**RFI**

RFI #: 164  
Date: 6/27/2012  
Job: EB-02 Keller Springs Lofts  
Phone: 877-777-5115

Subject: Connection Details Needed for Club Steel

RFI #: 129  
Date: 5/29/2012  
Job: EB-02 Keller Springs Lofts  
Phone: 877-777-5115

1 TYPICAL BEAM TO COLUMN CONNECTION DETAIL  
NO SCALE

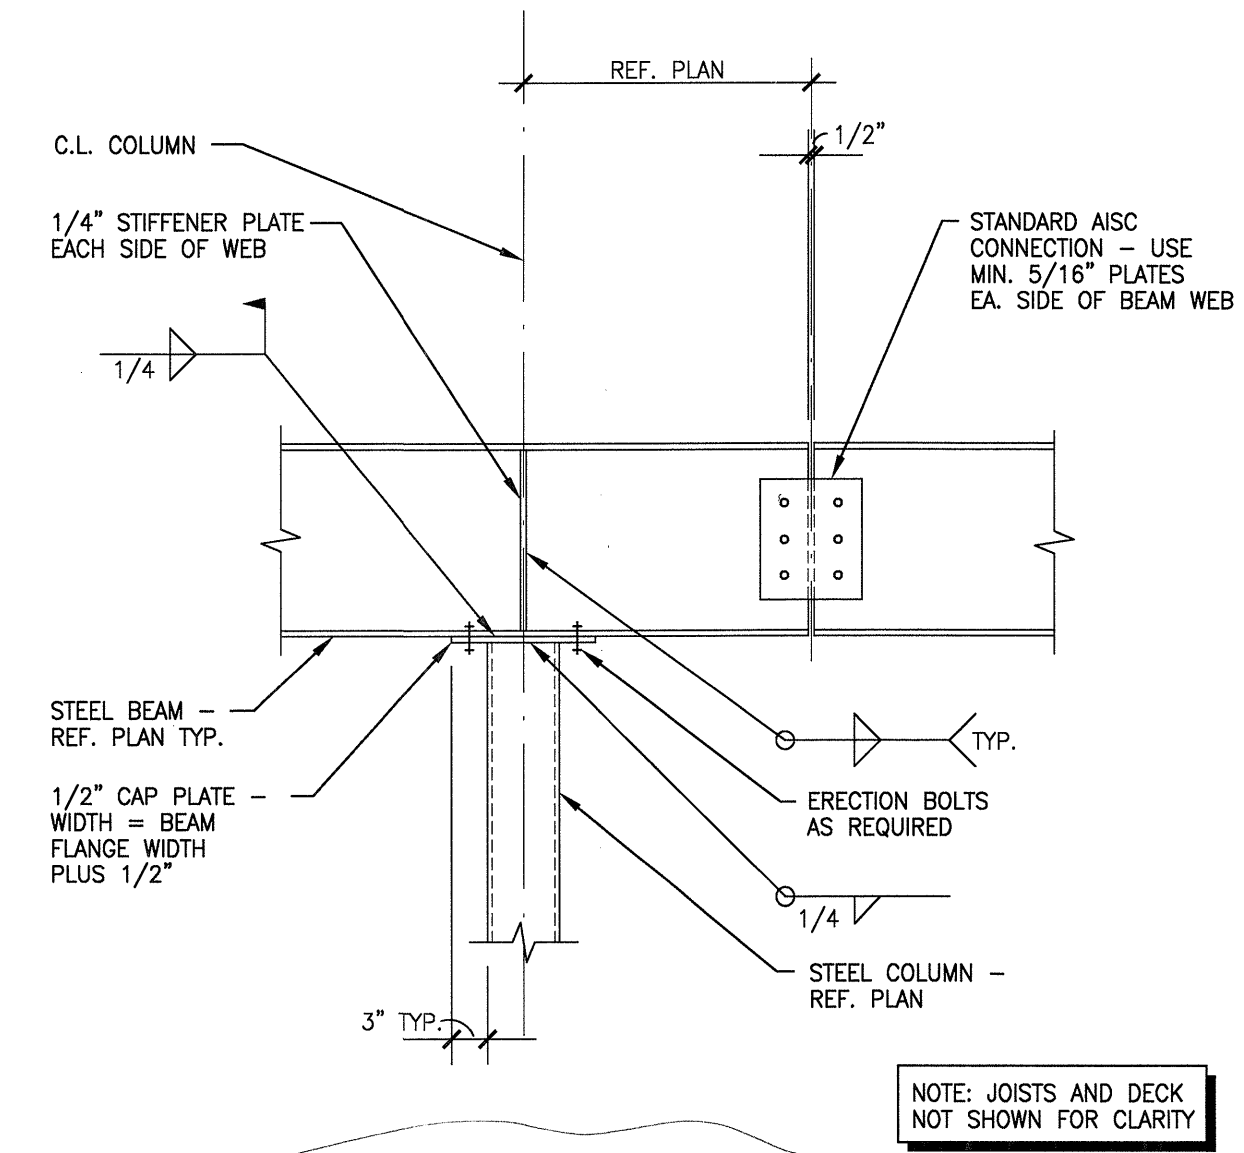
**Request:** Date Required: 6/28/2012  
We received a Non Compliant report from our testing lab which says that the connection utilized in the field was not shown in the drawings. Please see the attached report and provide a connection detail for the locations shown.

Please provide a bearing connection as indicated in details 1/S4.01 and 2/S4.01 of the Structural Drawings and Detail B of the Structural Steel Shop Drawings.
